Application for Planning Permission for Works or Extension to a Dwelling

Development Flat roof dormer to the front elevation. This application also falls within the parish of Pagham
Location 23 Lincoln Avenue Rose Green Bognor Regis

I regret that I am unable to accept your documents as a formal application until the following item(s) have been received or resolved :-

Rooms in Roof      Drawing No: SB/13/163/2      Date: Sept 2013

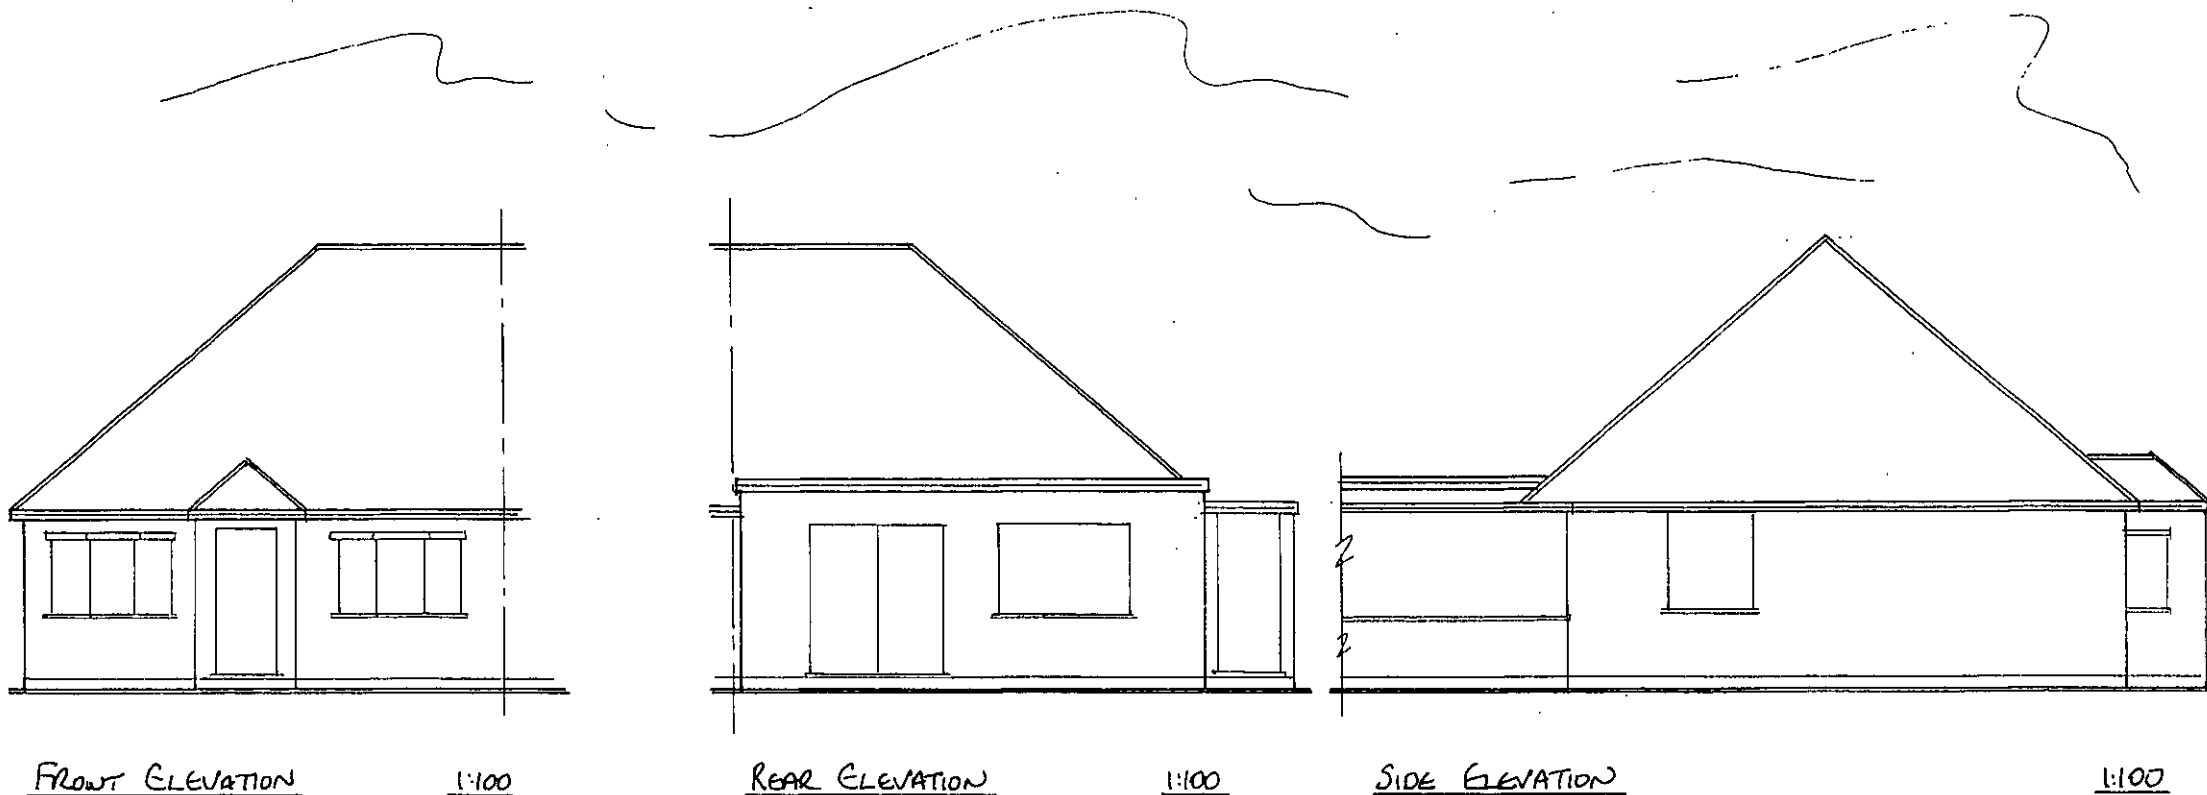
Block Plan

- ✓ Please submit 1 electronic or 3 paper copies of a revised block/site plan at a scale of 1:500 or 1:200 with written site dimensions including those from the dwelling to the site boundaries. Further details of what must be included on the plan can be found in the National Validation Requirements.
